Our Ref: PR115191-1
Your Ref: SSD-4972
Date: 26 October 2012

**RE: SUBMISSION TO DEVELOPMENT APPLICATION (REF: SSD-4972)
FOUR POINTS BY SHERATON HOTEL EXPANSION
161 SUSSEX STREET, SYDNEY**

The development application (Ref: **SSD-4972**) is currently on exhibition until Friday 26 October 2012. The proposal comprises the construction of a 25 storey tower at the southern end of the site which will include 231 new hotel rooms on levels 1 to 14, seven storeys of new commercial office space on levels 16 to 22 and two plant levels.

DEC 21 12PM

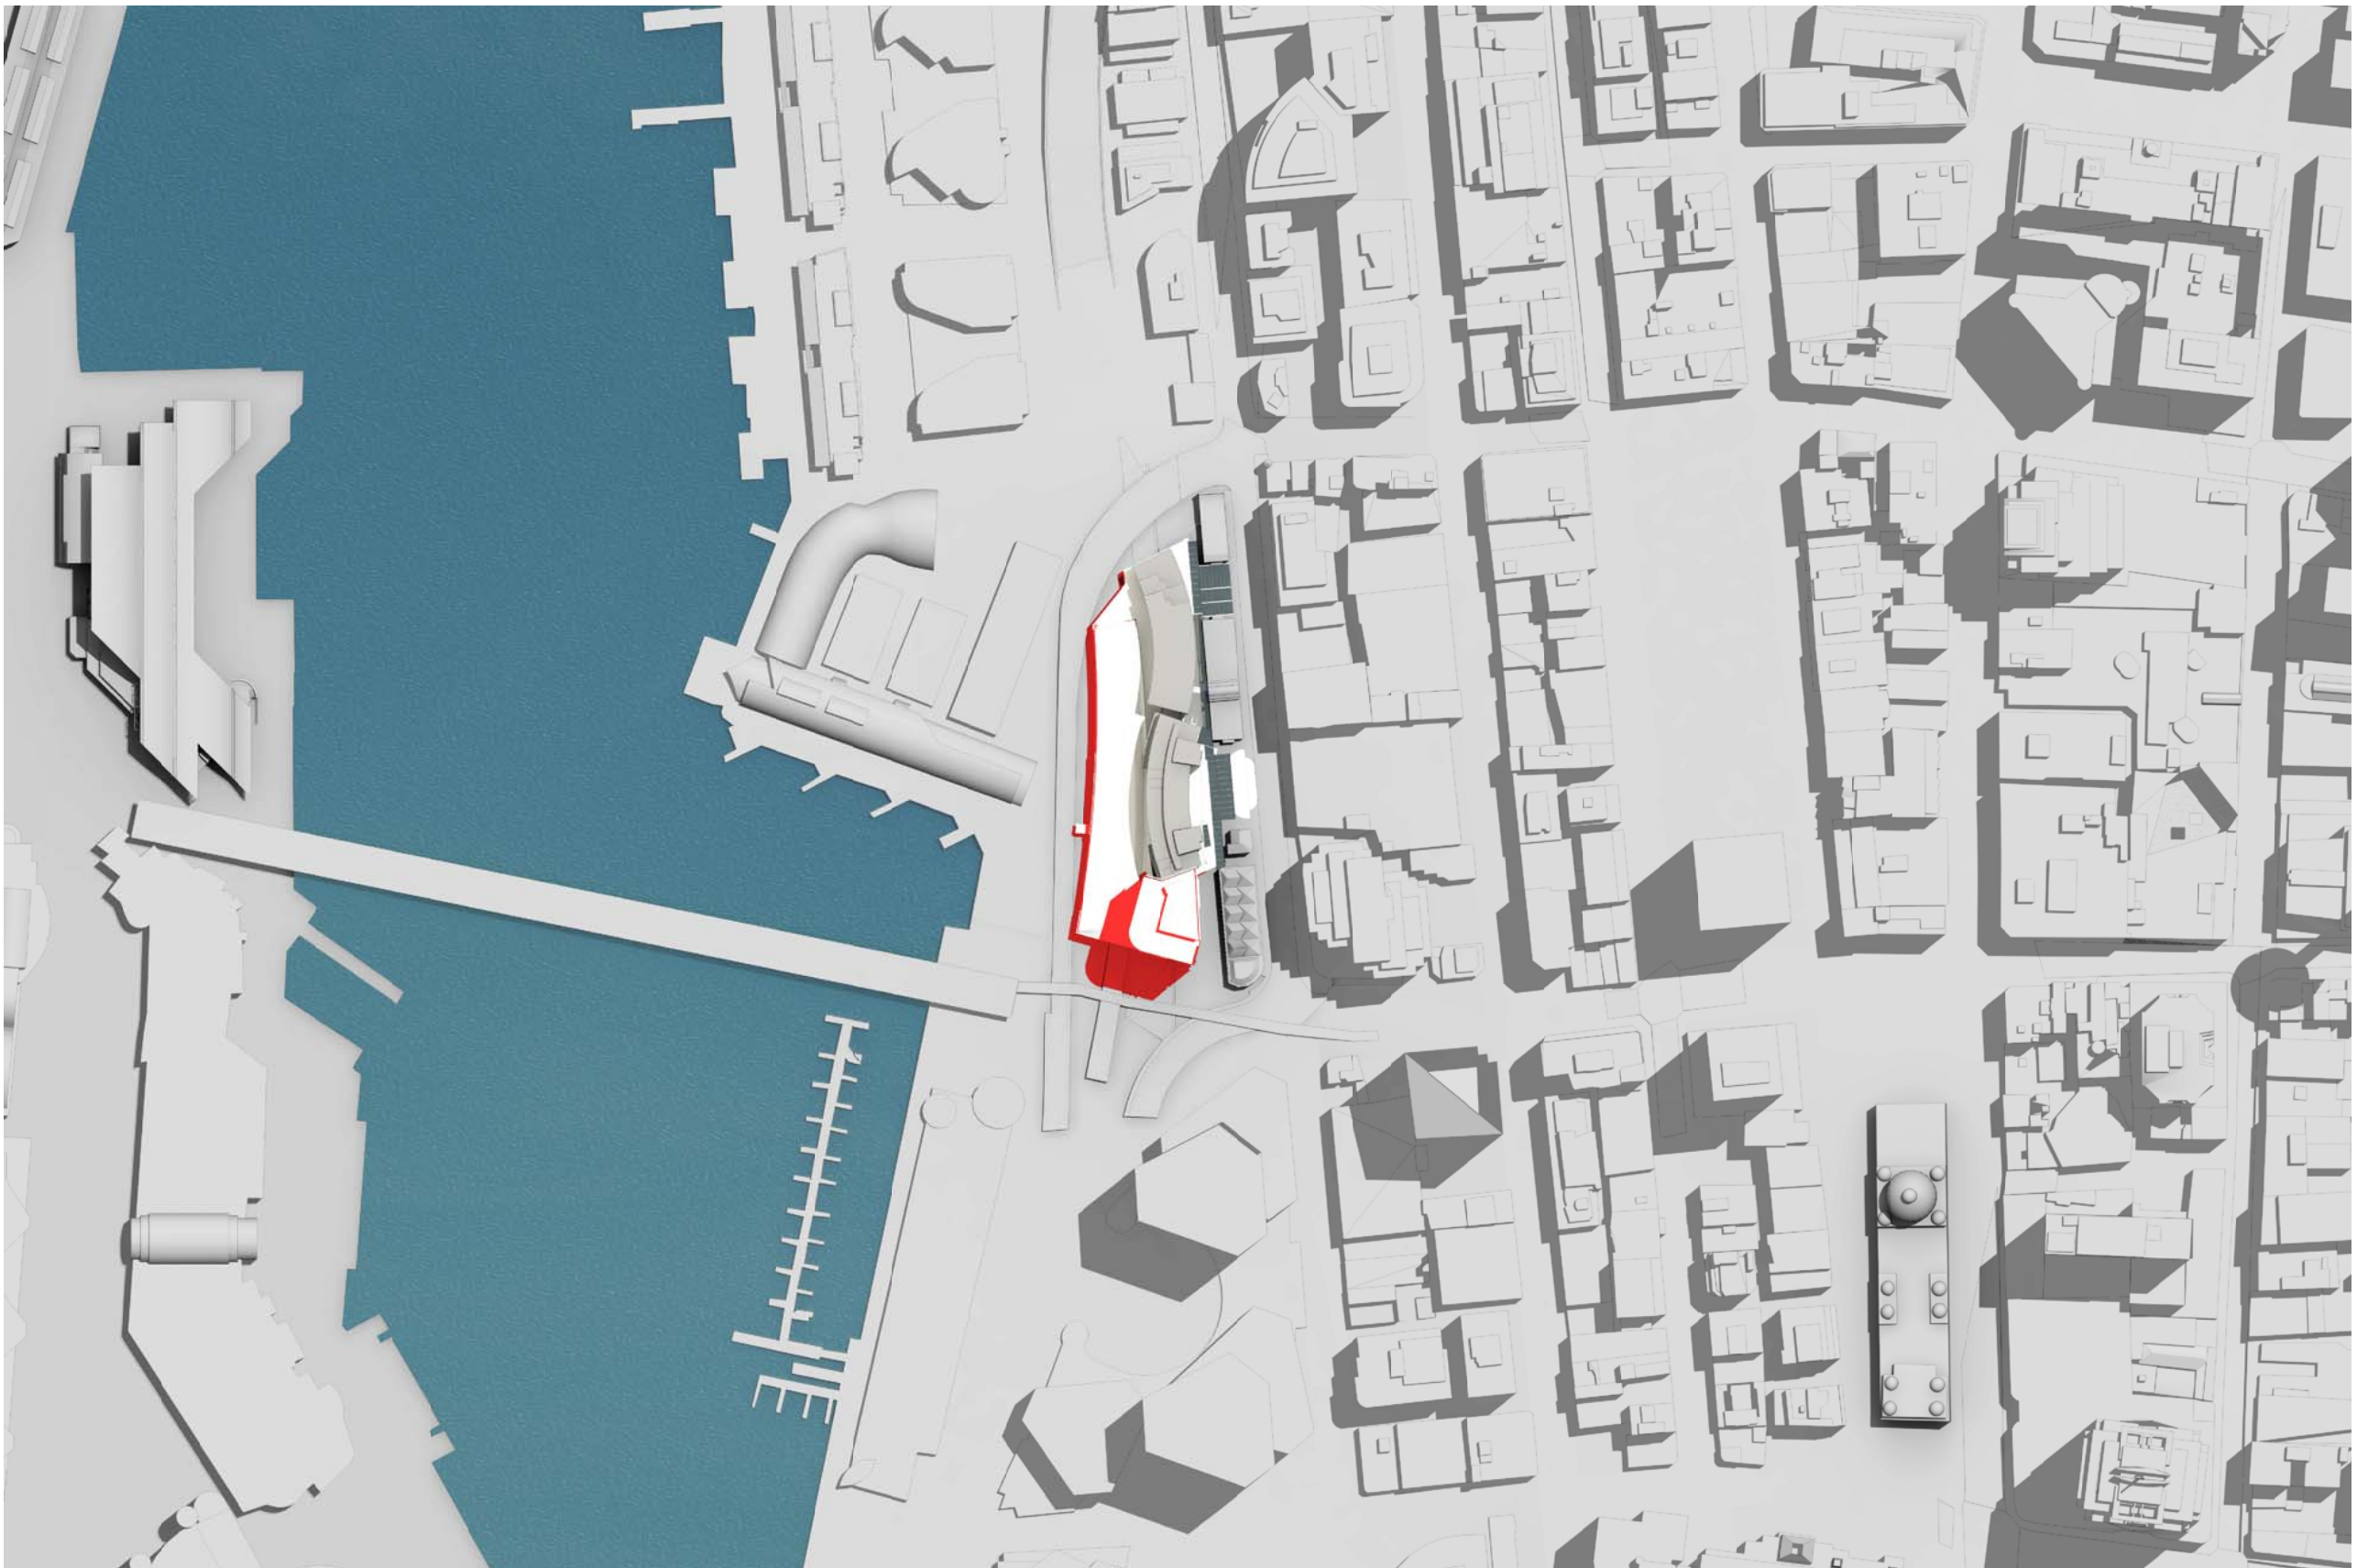
The solar study prepared by Cox Richardson identifies that the proposal will result in significant overshadowing over Darling Harbour to the south east on June 21 at 9am and west on December 21 at 9am. The study demonstrates the proposal will overshadow the Darling Harbour waterfront pedestrian area during the morning throughout the year (refer below).

Darling Harbour is an important Sydney icon. The level of overshadowing that would be caused by the proposed development in its current form in this area is considered unreasonable.
